Re: US Eagle Credit Union – Menaul
7201 Menaul NE
Traffic Circulation Layout Re-Submittal
Engineers Stamp Date 11-24-20 (H19D090)

Enclosed for your review is a copy of the US Eagle – Menaul Traffic Circulation Layout. Below is a brief description of how the comments from your response letter (dated 12/03/20) were addressed:

Revisions:
1 Addendum #1 - 1/20/2021
Issue Date: 1/20/2021
Architect: B. Bily
Drawn By: PS
Checked By: MS
Project Number: 29643-0000
Title: SITE DETAILS
Sheet No. C-101

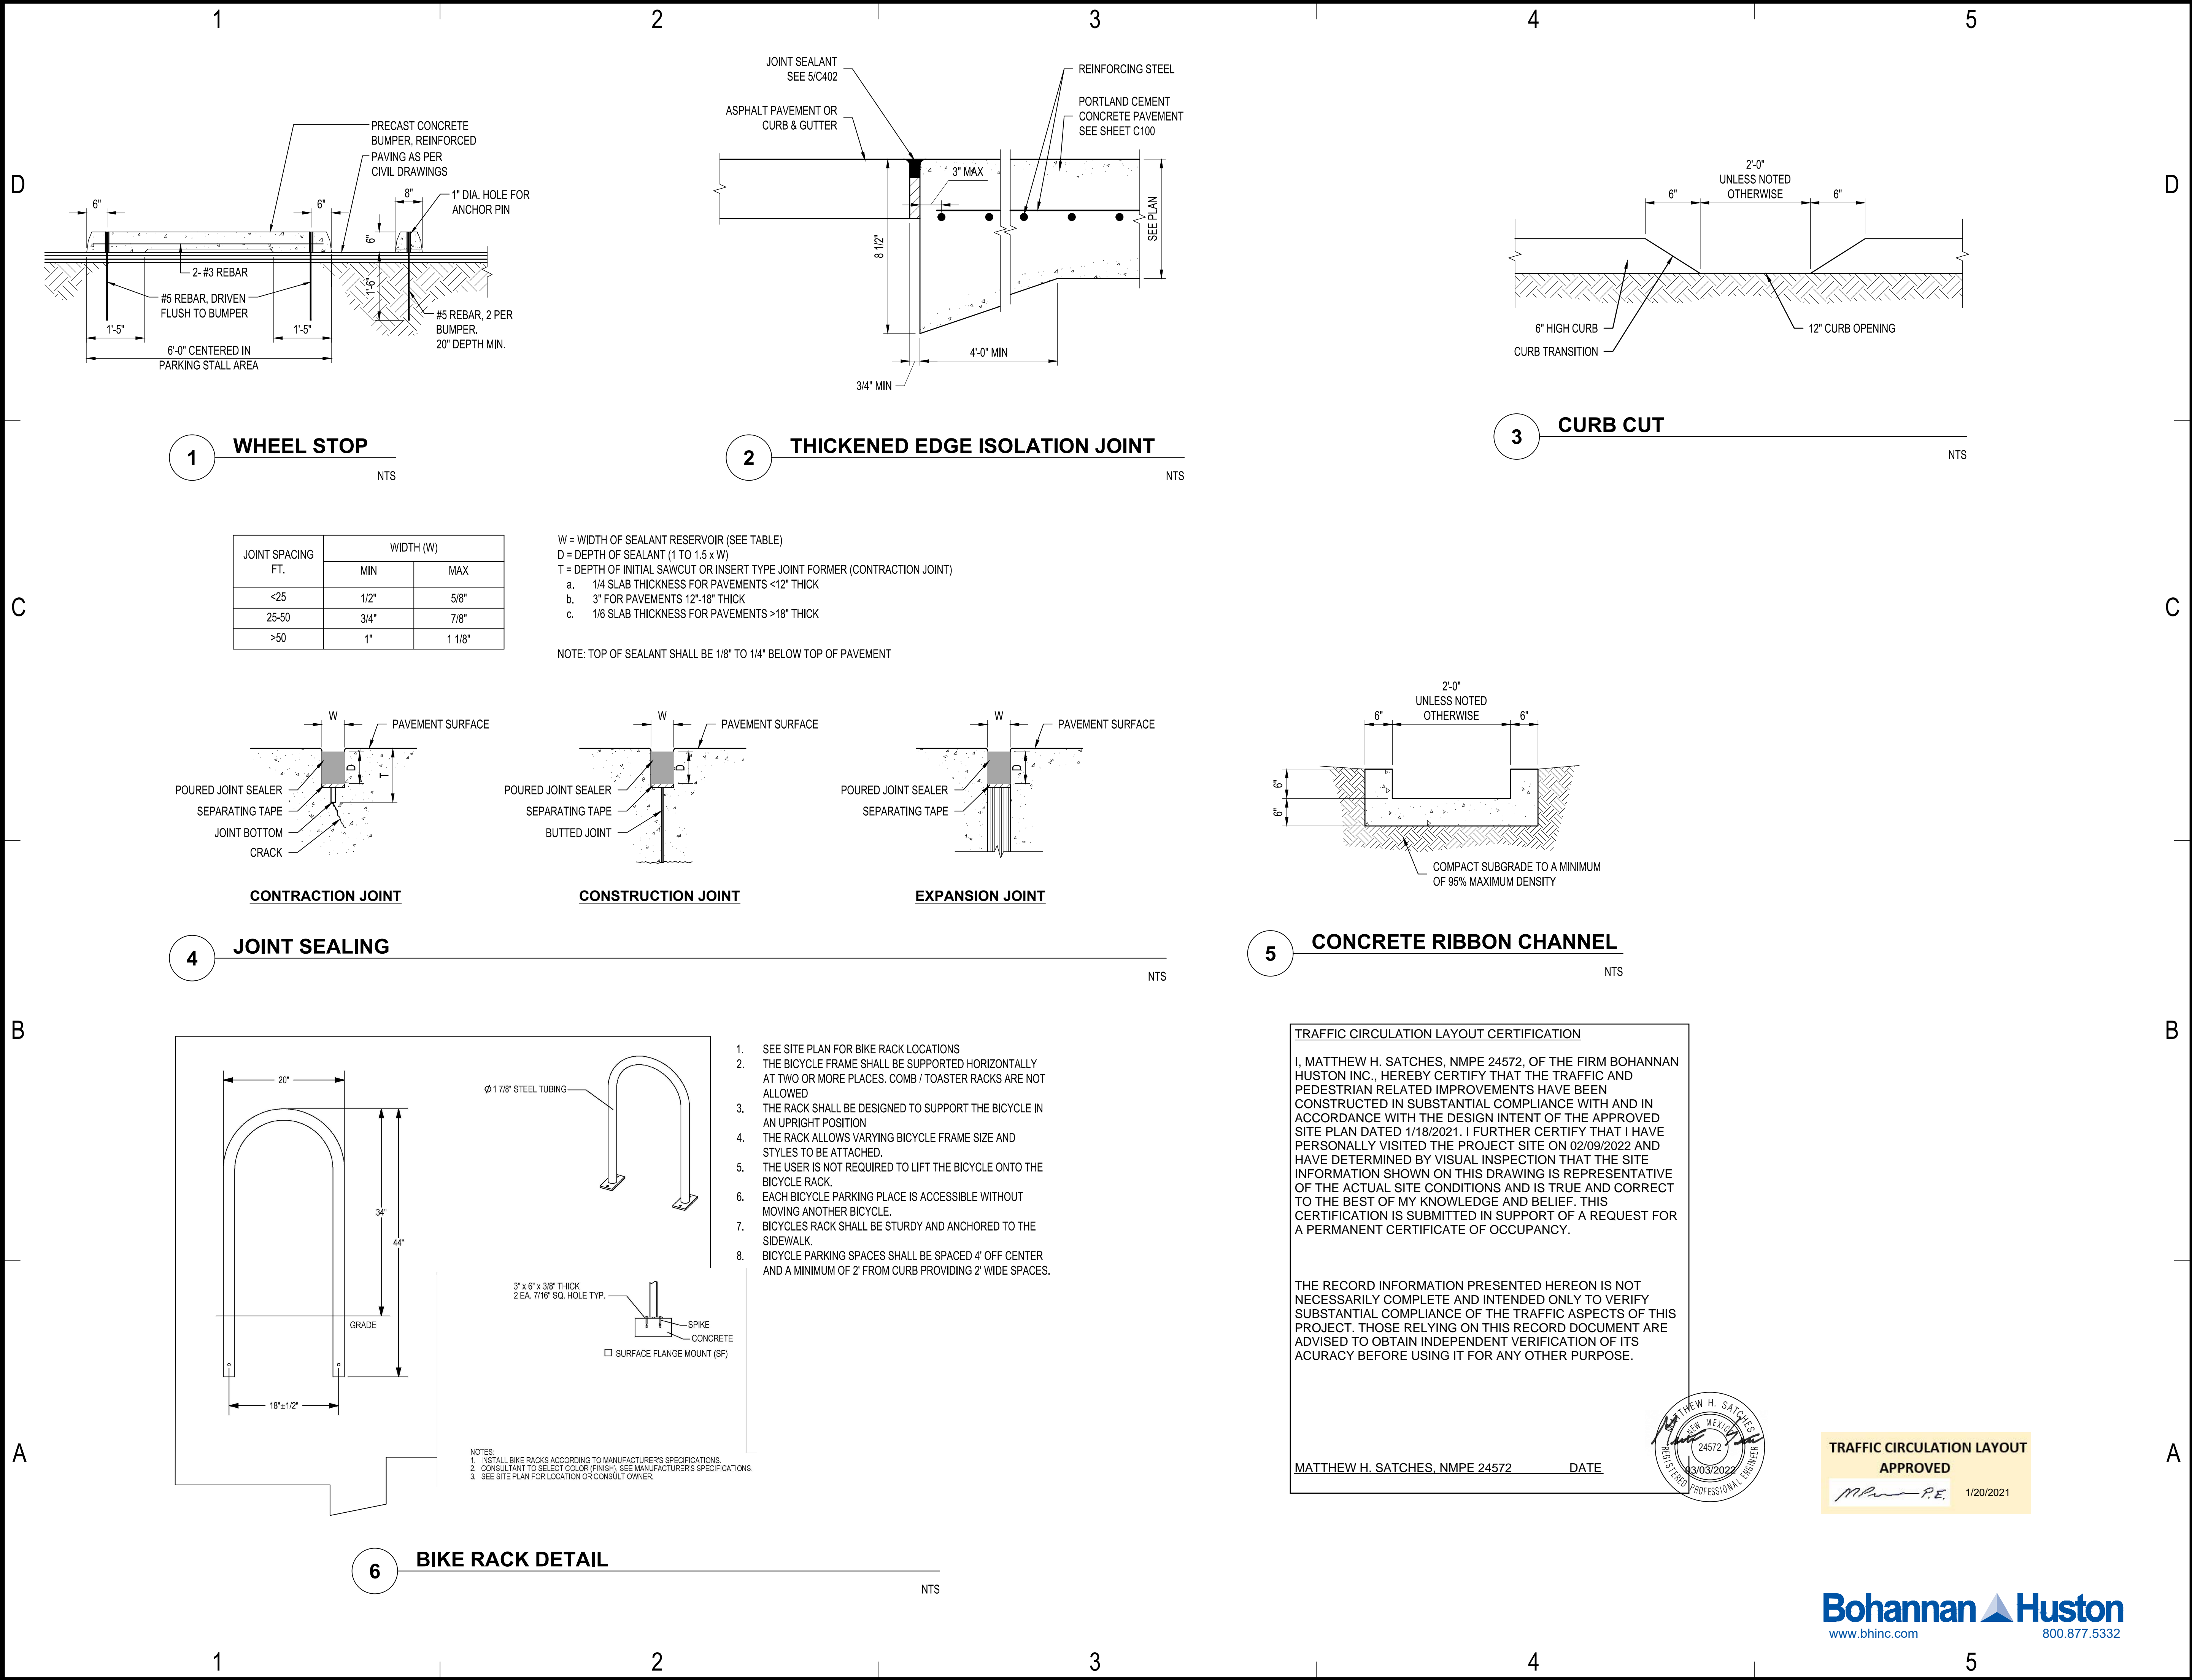
2. Add notes referencing sheet C-101 for the proposed ADA ramp status on the northern segments of Espanola St. and San Pablo St. abutting 20 ft. Alley on sheet C-100.

Response: Keyed Note 3 references the detail on C-101 regarding the ADA ramps at the Alley and Espanola St. and San Pablo St.

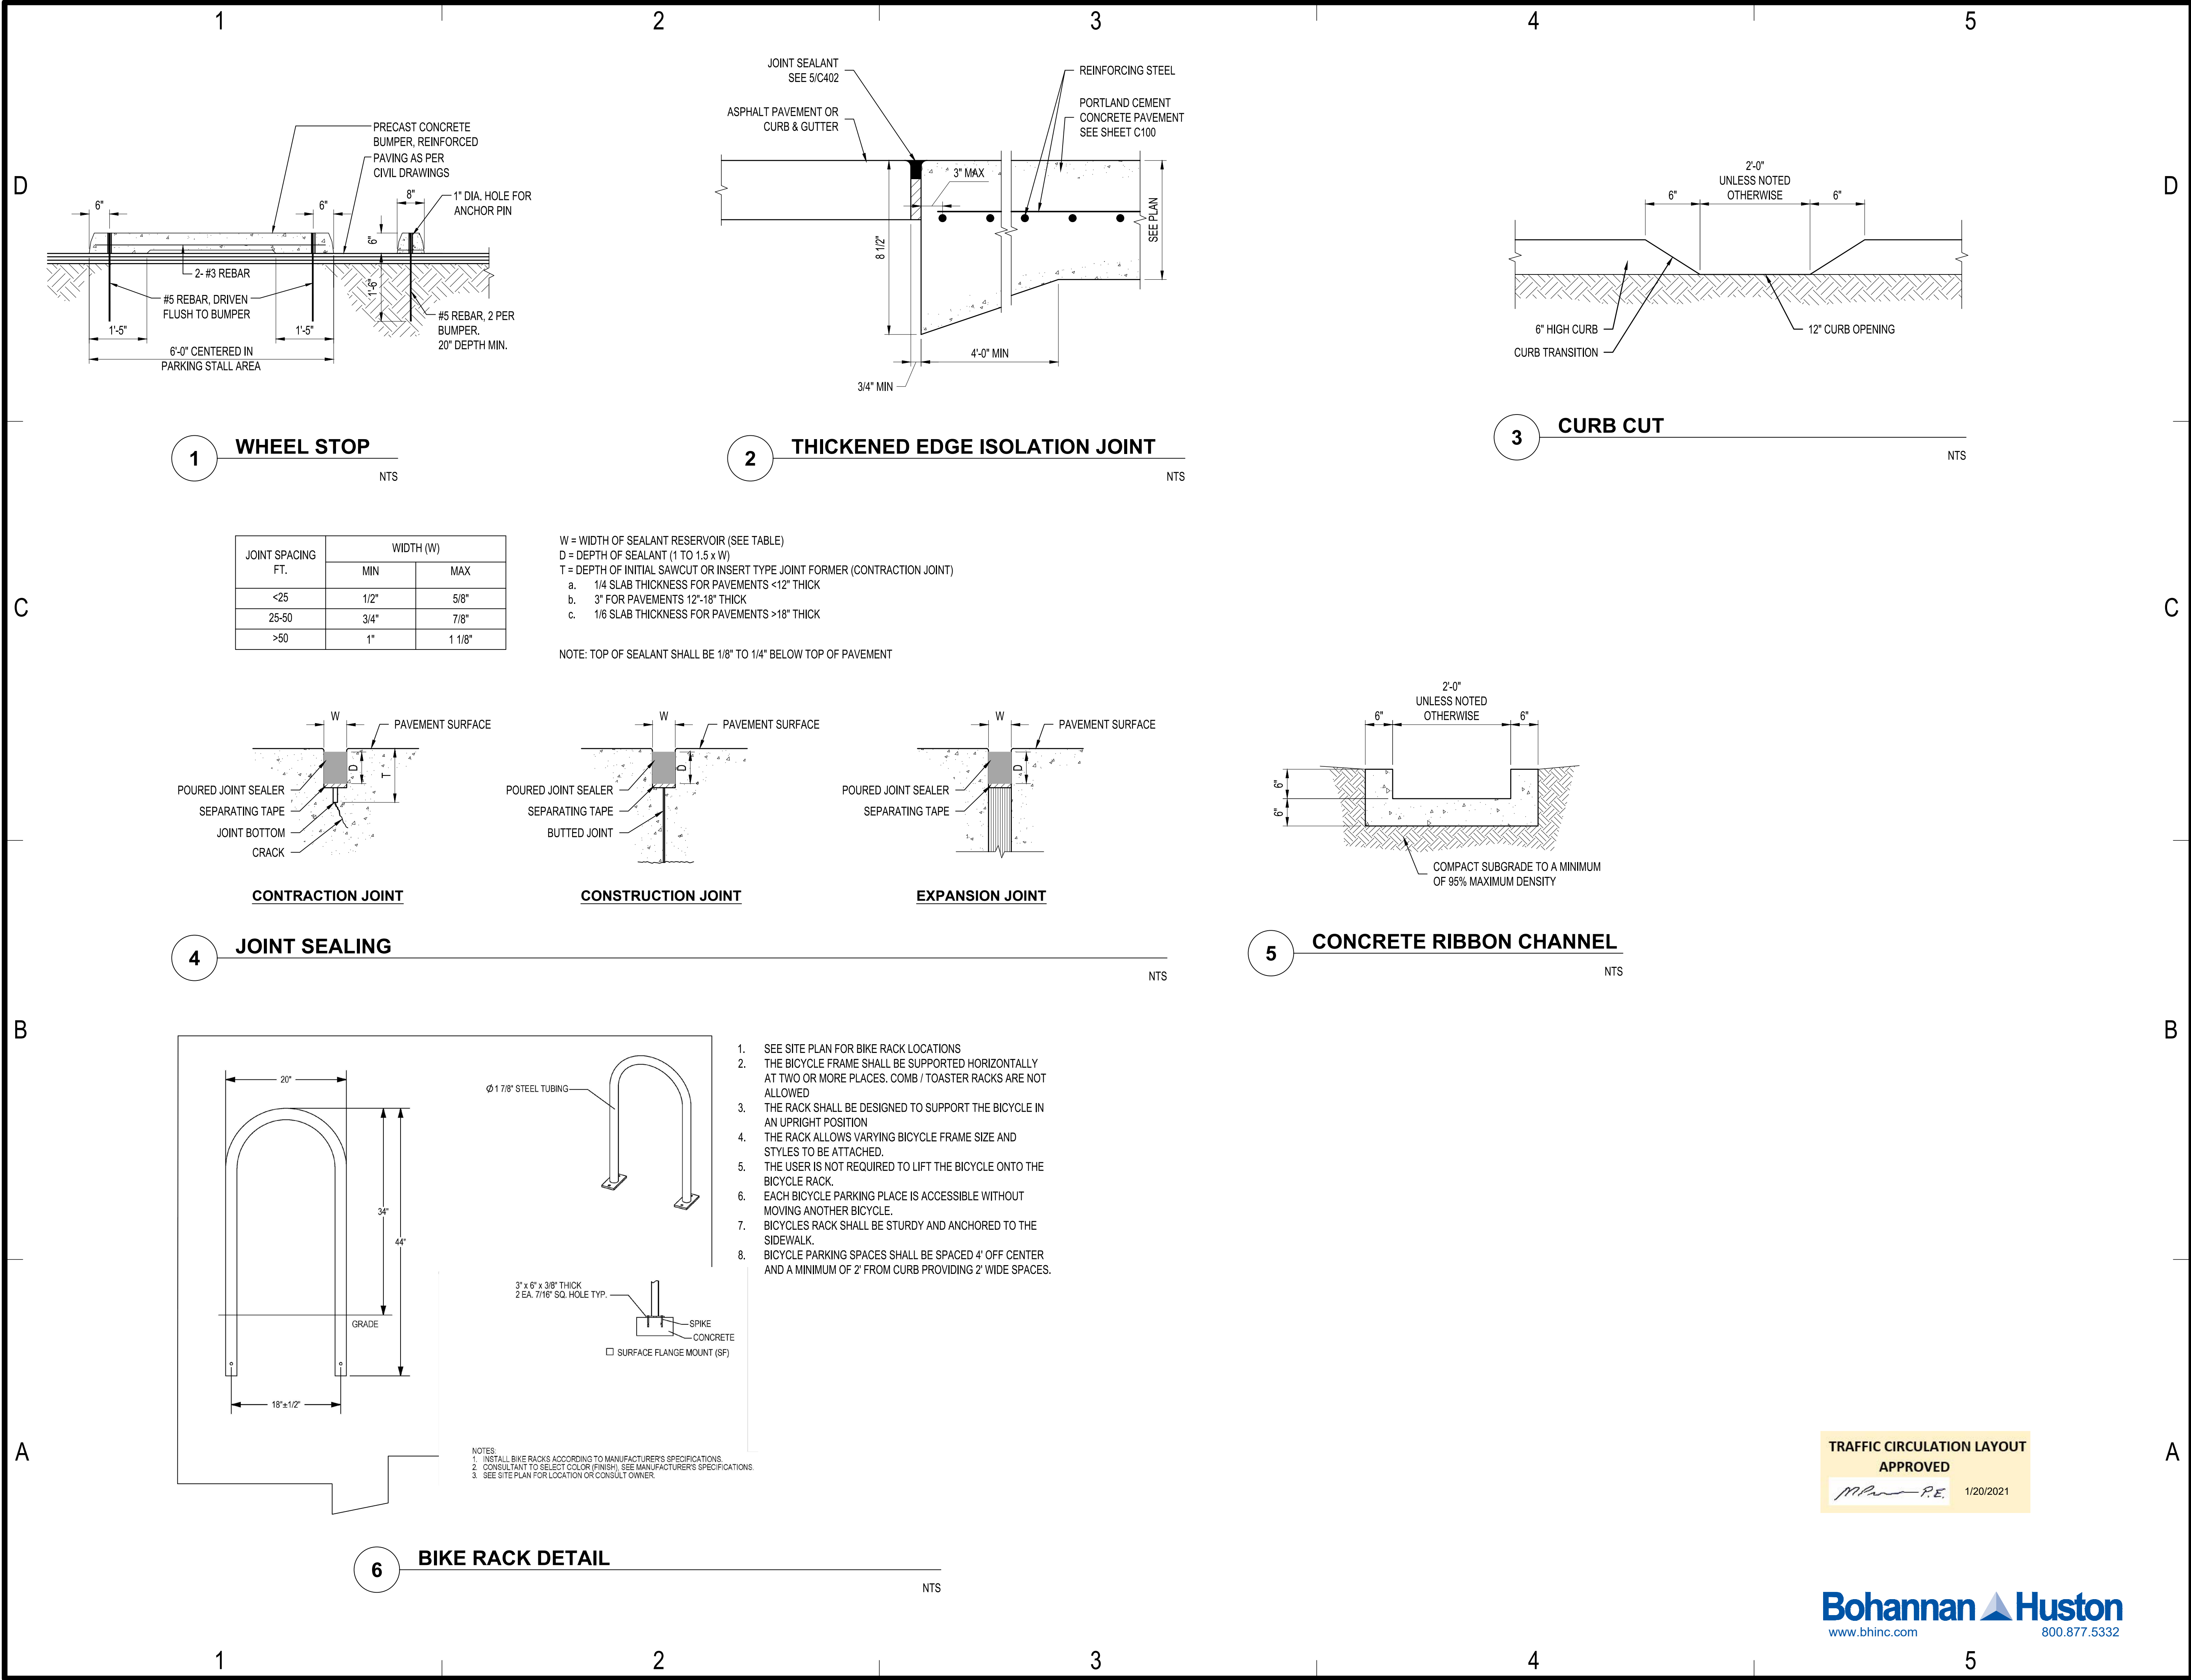
1. KEYED NOTES: All keyed notes referencing MUTCD and Architectural Plans will need details on these sheets. Please do not reference different manuals or spec's unless they are COA std dwg numbers. The proposed sign face detail will need to comply with MUTCD and detail will need to be provided.

3. Espanola entrance pavement markings will need 'Do Not Enter' and the proposed pavement bar will need to be located on private property.

5. Add note on proposed bollard to be painted yellow.

Response: The reference to MUTCD has been removed from the Keyed Notes and details added to the plan.

Response: Markings 'Do Not Enter' and stop bar have been moved onto private property.

Response: Keyed Note has been updated to have bollards painted yellow.
